Detention Agreement V_2.pdf Markup Summary

Developer desires to maintain for the subdivision One (1) "Open" (detention basin (DMF)) as the means for runoff control and to meet requirements of the County's MUD, maintaining and repairing such detention basin (DMF).

Developer desires to maintain the existing detention basin as shown on [Tract D, Silverado Ranch Filing No. 1](#) and as set forth on [Exhibit B](#).

SILVERADO RANCH FILING NO. 1
 IN THE NORTH HALF OF SECTION 16, T15S, R63W, 6th P.M.
 EL PASO COUNTY, COLORADO

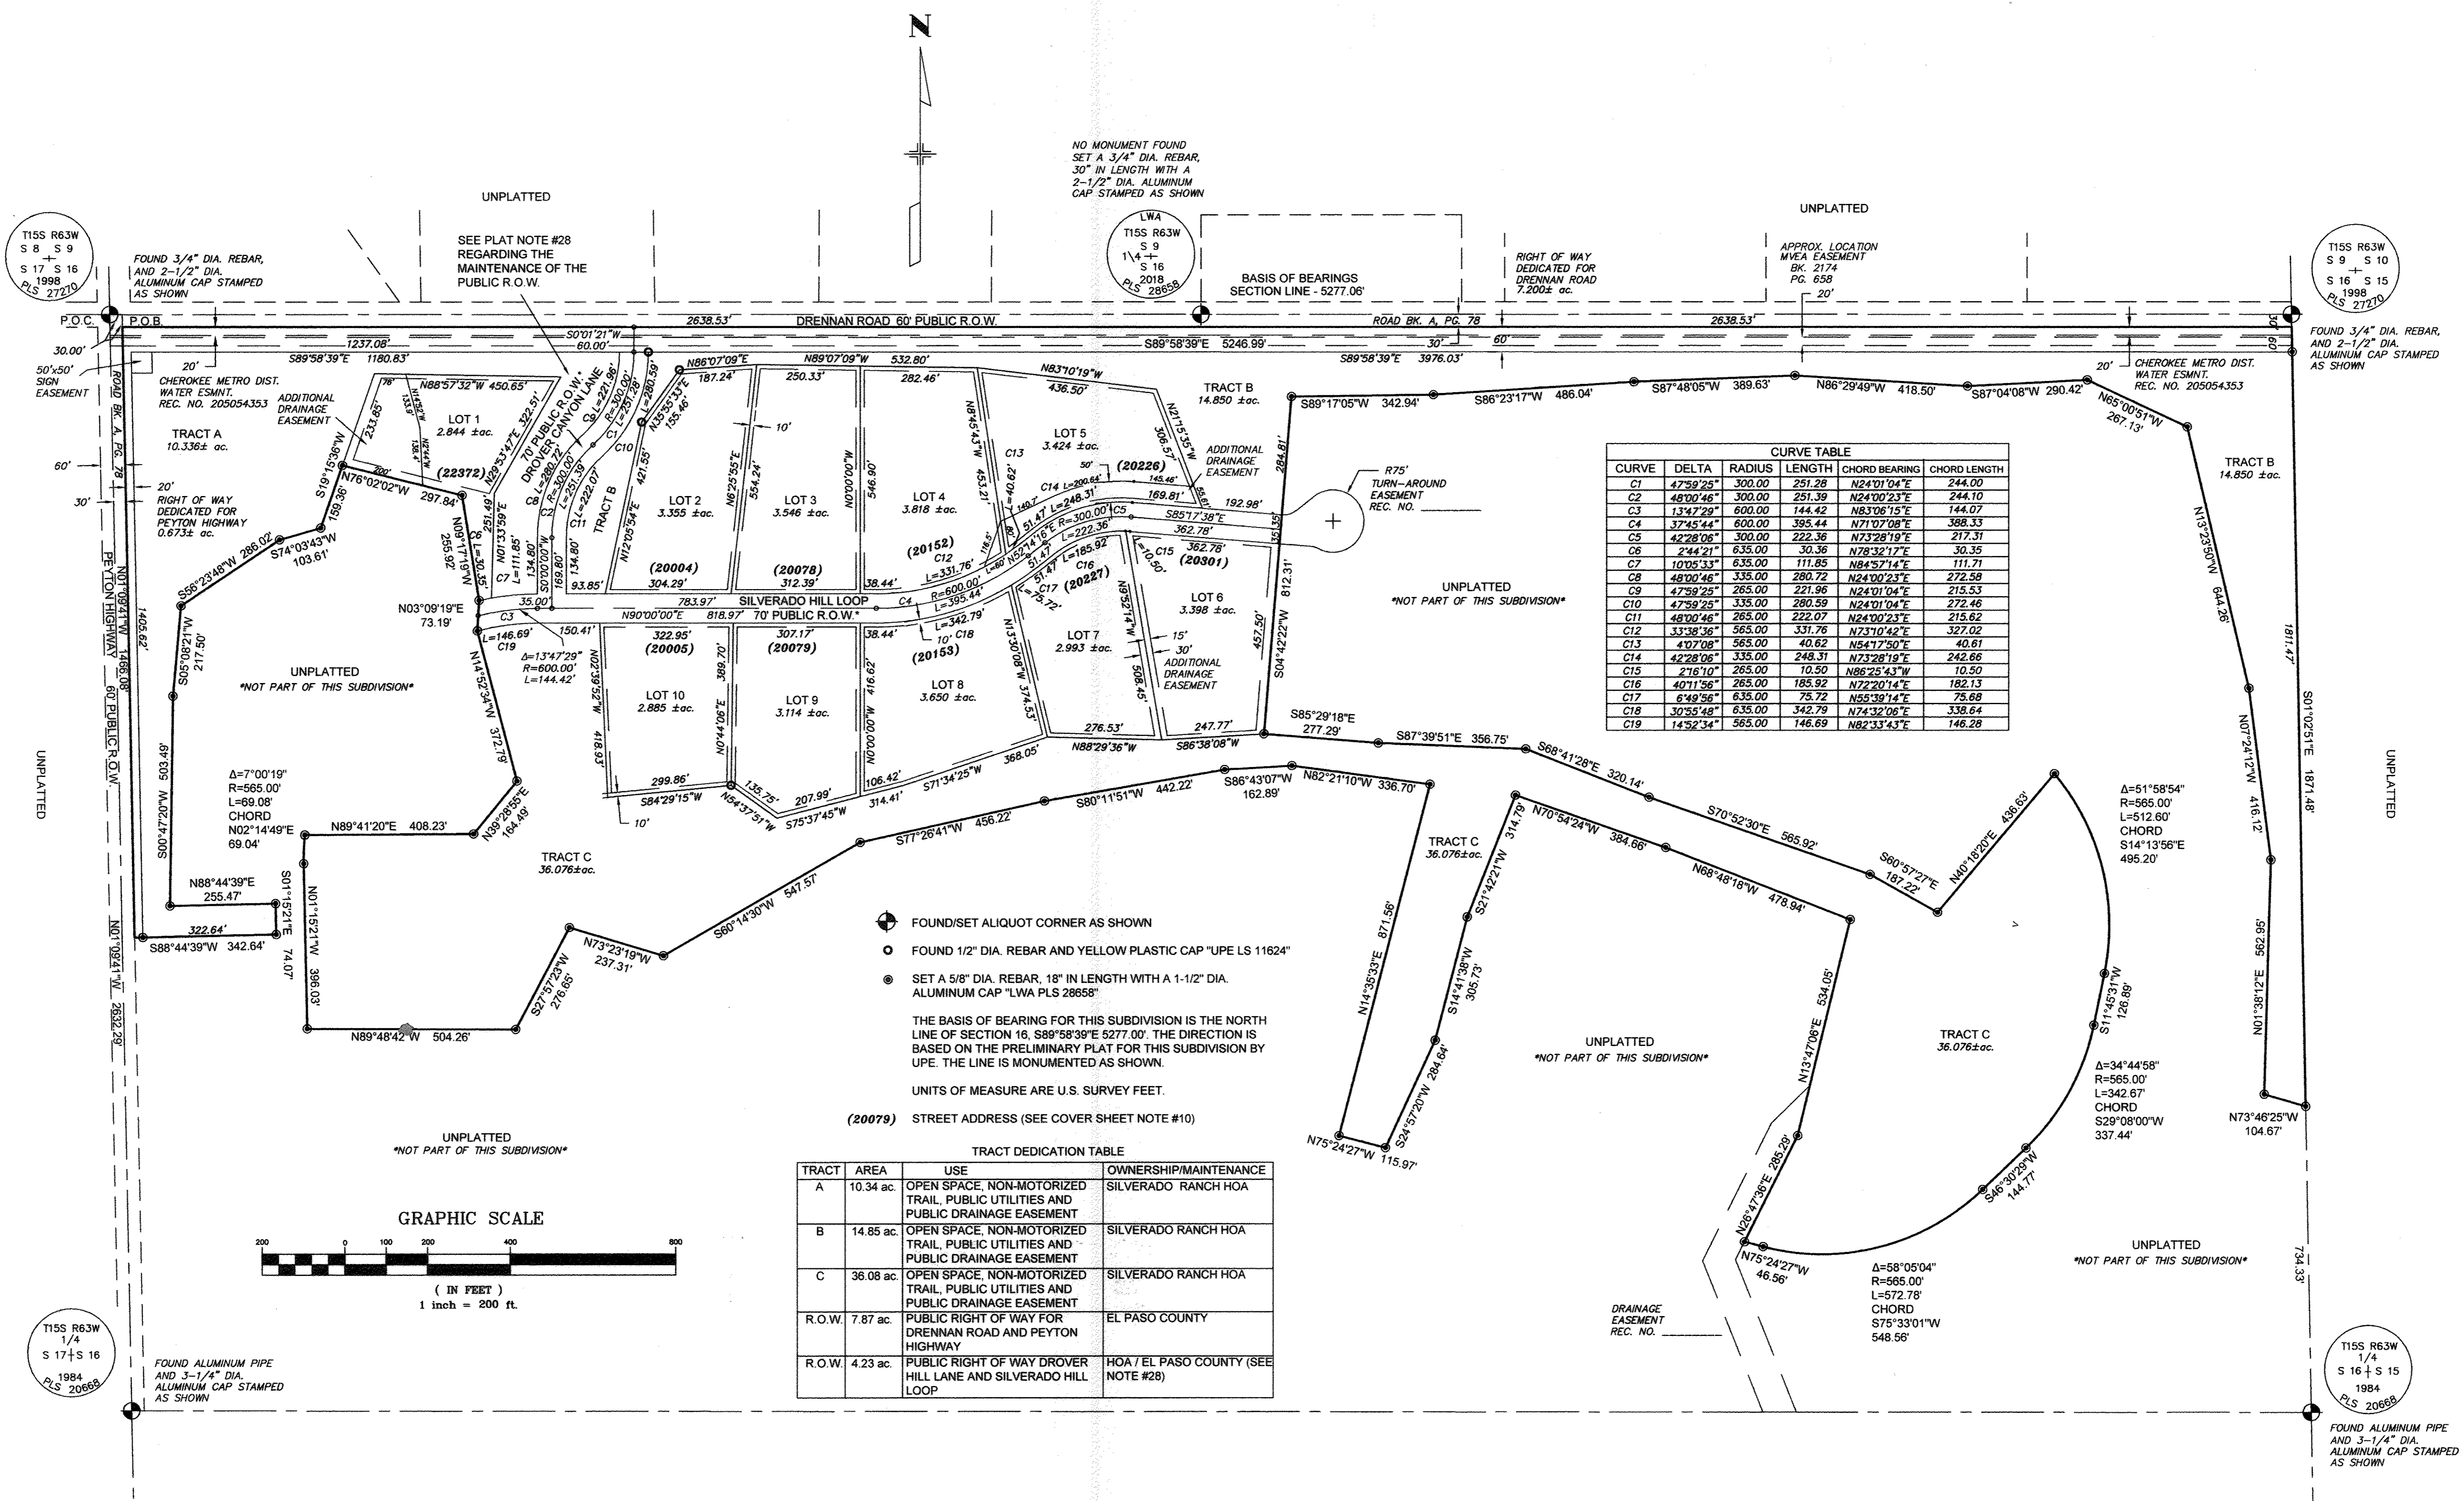
EXHIBIT B
see: [Tract D, Silverado Ranch Filing No. 1](#)
